Addition of first floor to existing bungalow to allow conversion to 2 x 1 bedroom flats and a studio flat.

38 Chalcraft Lane Bersted

Thank you for your internet representation made on 20th May 2019 which has been recorded as '**an objection**' with the comments as follows:

PROPOSED SITE LAYOUT 1:200

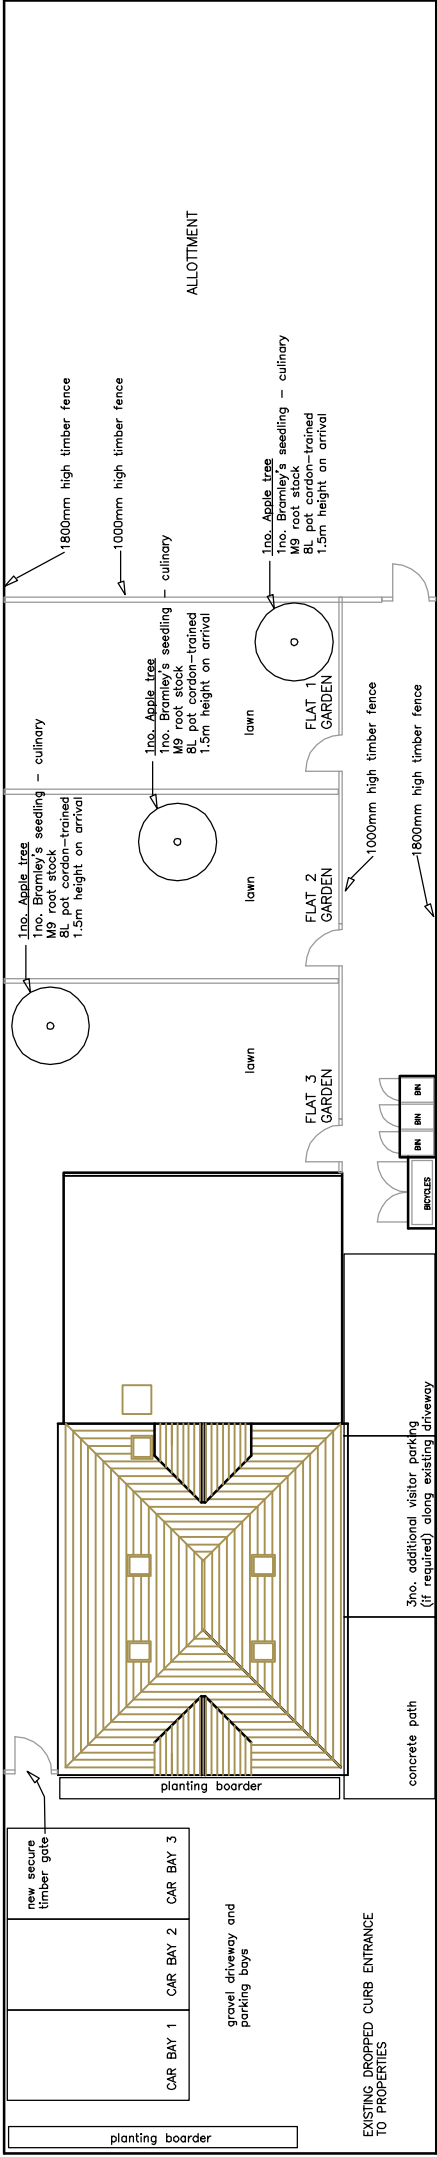
The site plan does not show my recent kitchen extension. Taking this into account I am concerned that the proposed bin storage area will be close to my kitchen with potential of smells, fire risk, vermin and noise. Also the cycle store could cause similar problems especially noise.

The site plan also shows the garden divided into three with a large area to the rear of the garden not used. Is this being left for some particular reason? This part of the garden is already overgrown and my fencing has deteriorated following this neglect and I am keen to know this will not continue before considering replacing the fence. Also would further development of the site be considered.

The site plan also shows three parking spaces. This I feel is inadequate as potentially there could be 5 or 6 cars at the property. This would then lead to cars parking on the grass verge which obscures my view when pulling out, and makes it difficult to see cars on the bend and puts me in a potentially dangerous situation. I would draw your attention to the Bersted Neighbourhood Plan which states 'minimum of 2 spaces per dwelling'.
